Application for removal or variation of a condition following grant of
planning permission. Town and Country Planning Act 1990.
Planning (Listed Buildings and Conservation Areas) Act 1990

Description	Land at the Southern End of Cinders Lane Cinders Lane Yapton BN180JJ
-------------	---

Approval of reserved matters following the grant of Y/32/17OUT for the erection of 19 No. dwellings. This application also lies within the parish of Climping & affixes a Public Right of Way

Y/26/20/RES

Drawing No : 97.17.P102_A

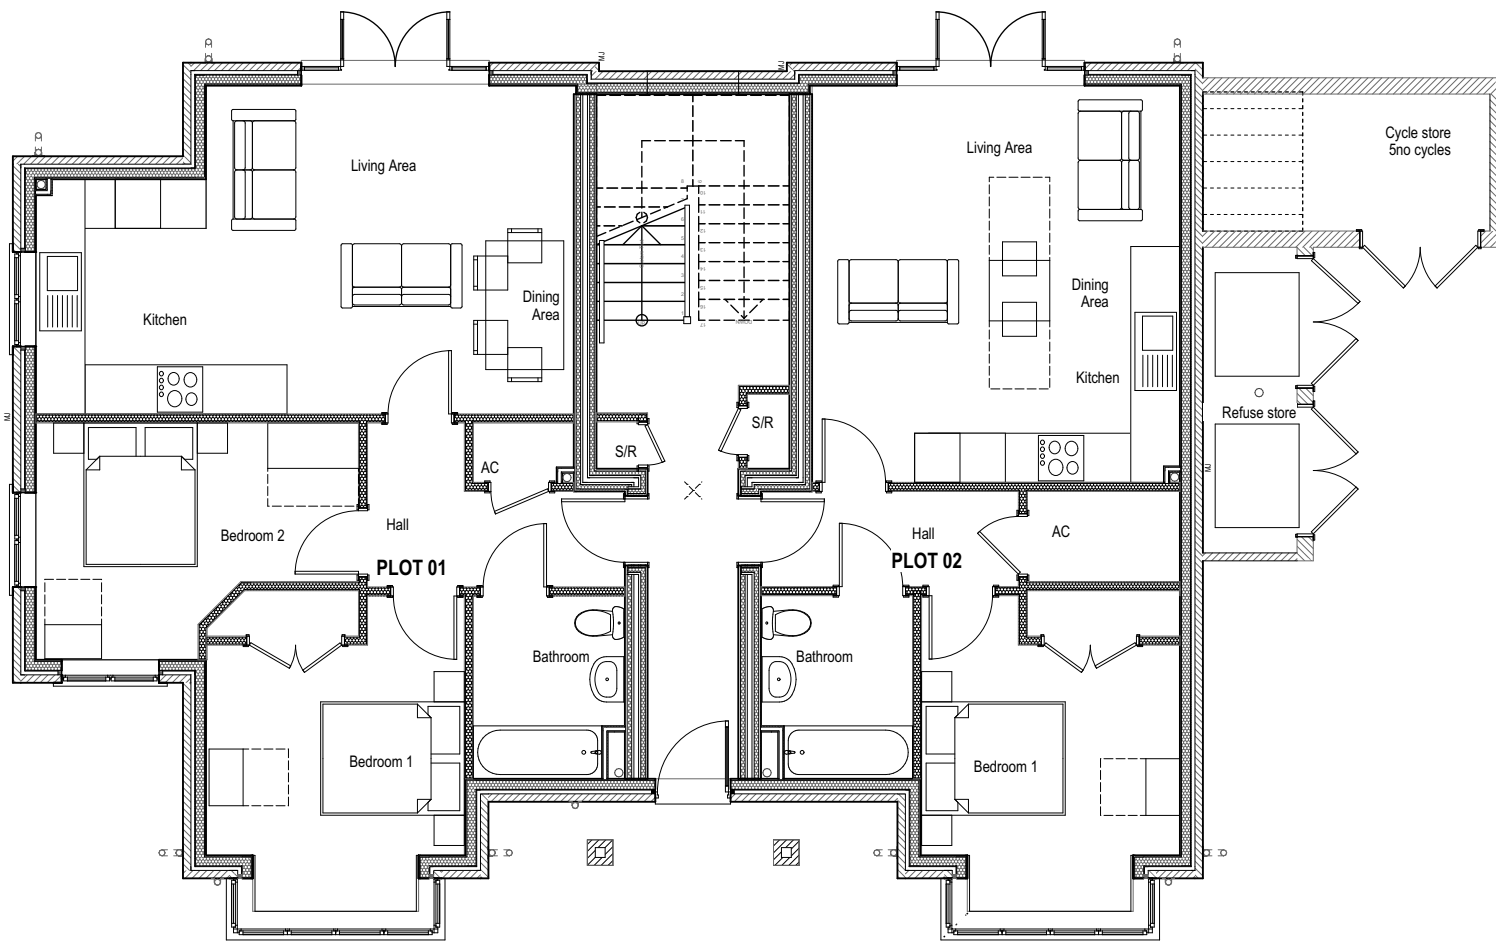
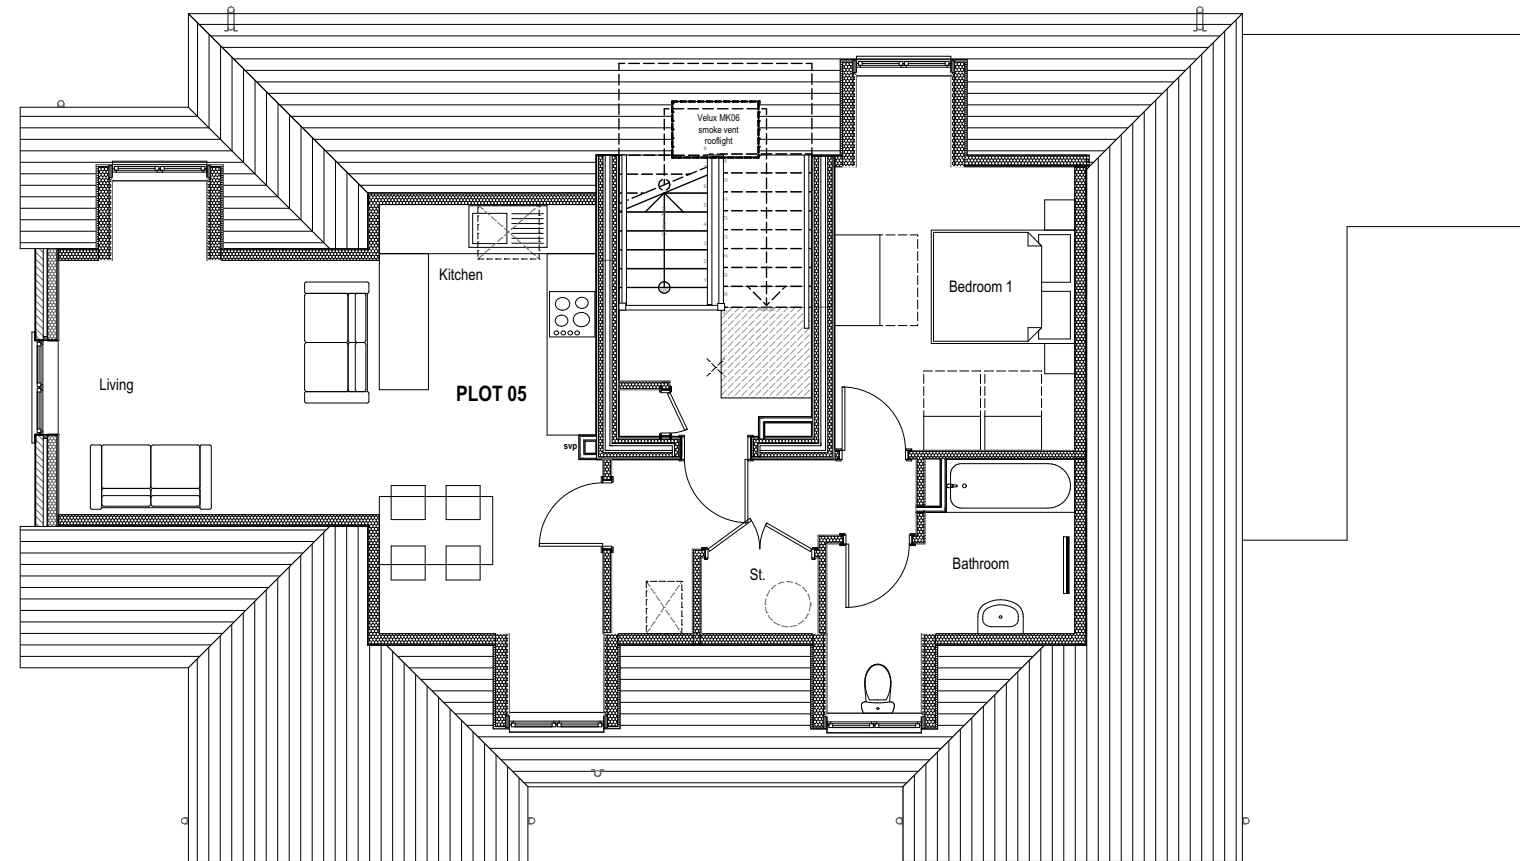
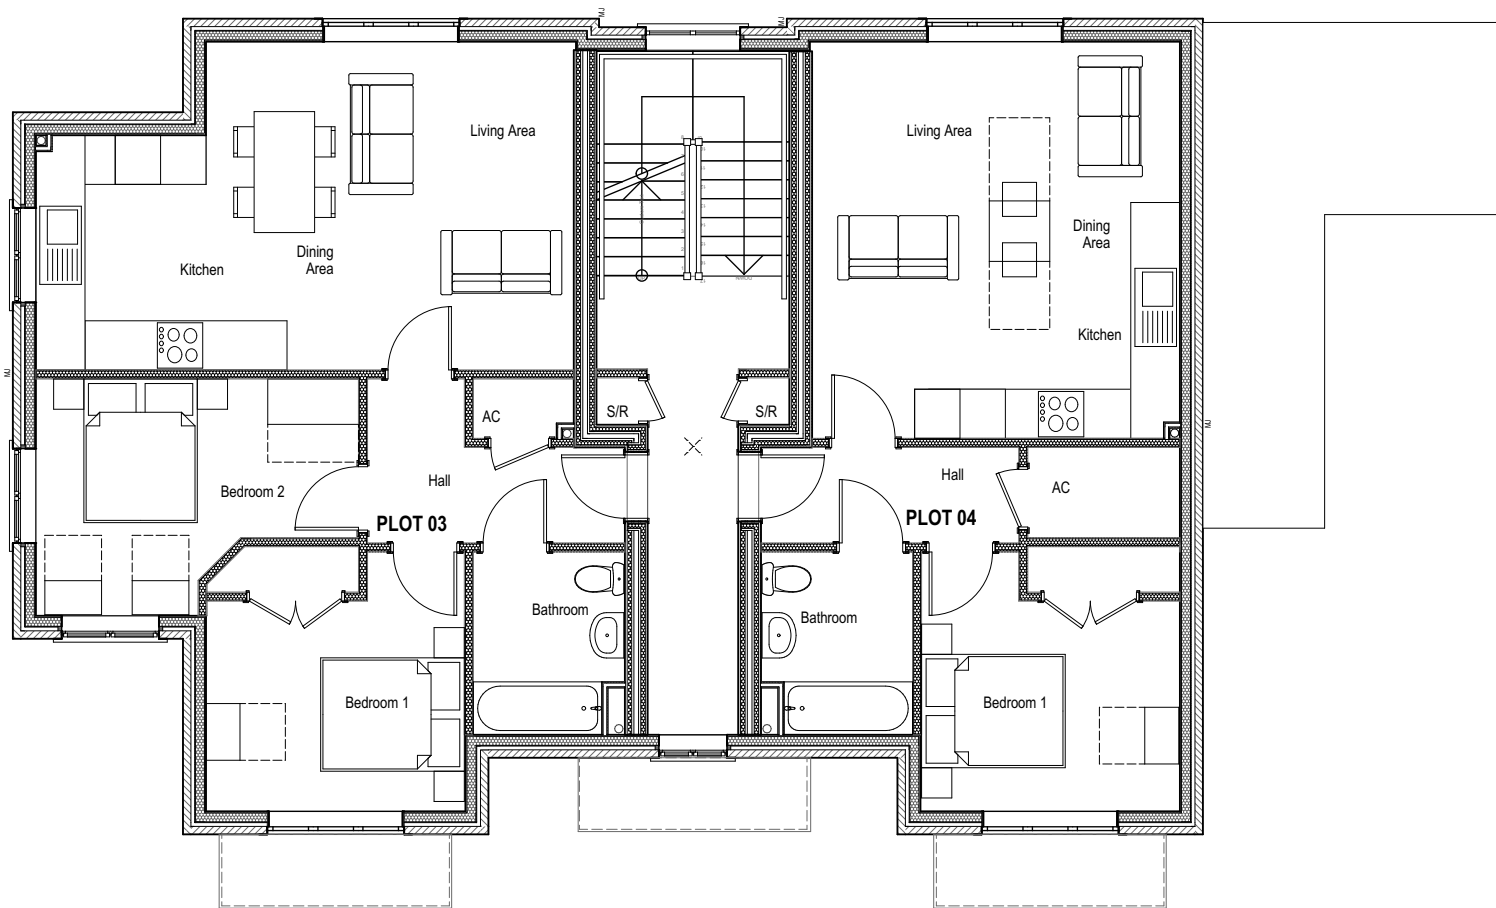
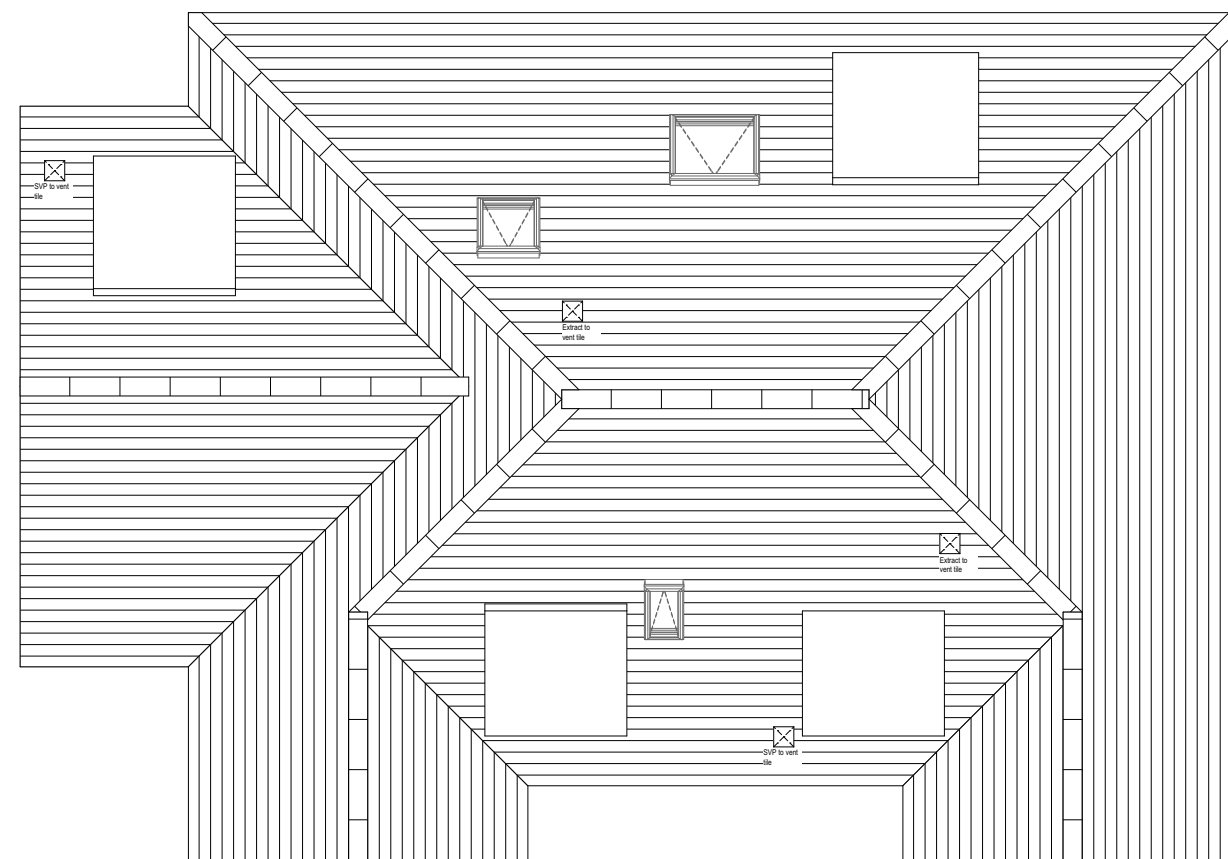
For the repositioning of the stairwell window, and increased eaves and ridge height of plots 1-5 (to provide adequate headroom for means of escape).
For the addition of obscured windows to bathrooms in the flank walls, and the repositioning of garage personnel doors to plots 8, 11, 16 & 17 (to provide natural light and ventilation)
For the addition of a rooflight to plot 18 (to provide natural light and ventilation)

97.17.P102 Plots 1-5 Plans replaced with 97.17.P102_A Plots 1-5 Plans
97.17.P102.1 Plots 1-5 Elevations replaced with 97.17.P102.1_A Plots 1-5 Elevations
97.17.P104 Plots 8 & 11 Floor Plans & Elevations replaced with 97.17.P104_A Plots 8 & 11 Floor Plans & Elevations
97.17.P105 Plots 16 & 17 Plans with 97.17.P105_A Plots 16 & 17 Plans
97.17.P106 Plots 16 & 17 Elevations with 97.17.P106_A Plots 16 & 17 Elevations
97.17.P107 Plots 18 & 19 Plans & Elevations with 97.17.P106_A Plots 18 & 19 Plans & Elevations
